From: Michael Eastham <Michael.Eastham@arun.gov.uk>
Sent: 07 August 2020 12:52
To: Planning.Responses <Planning.Responses@arun.gov.uk>
Subject: FW: A/86/20/DOC - Manor Nurseries, High Street, Angmering

Please upload onto Ocella the email below which is a further consultation response from **ADC Environmental Health** to discharge of condition application **A/86/20/DOC** regarding Manor Nurseries, High Street, Angmering.

Condition 24 (CL) – the majority of Ashdown Site Investigation Limited's Revised Ground Contamination Risk assessment Report (ref.: R14233 for project P14618, dated May 2020) is acceptable. The removal of the asbestos roof from the plant room is noted, however there is no information regarding when this is likely to have occurred, how the roof was removed nor where it went.

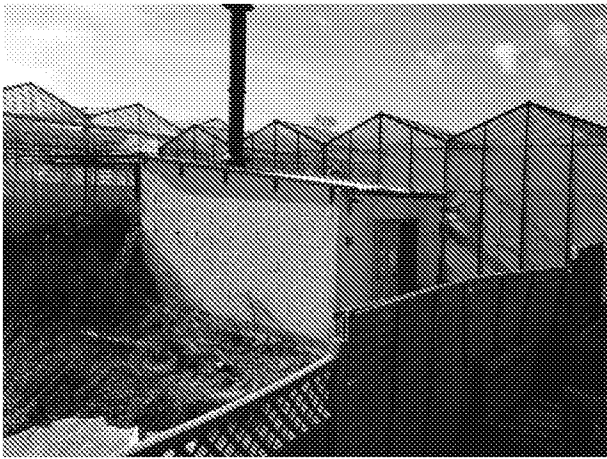
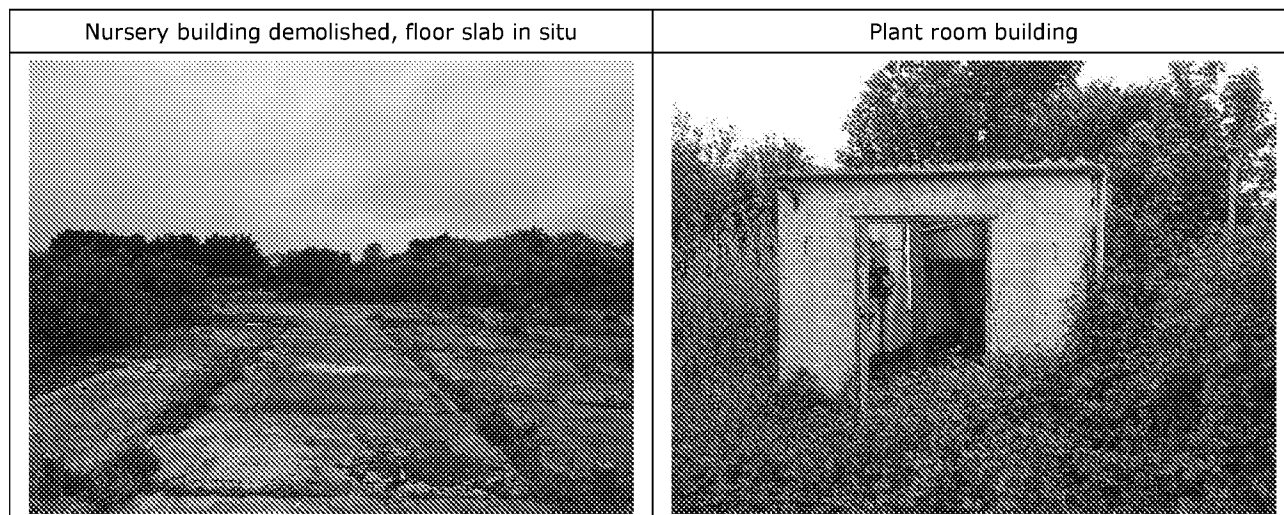
Condition 24 – the issue regarding the removal of the asbestos roof has not been addressed.
Other than this, EH have no further comments at this stage.
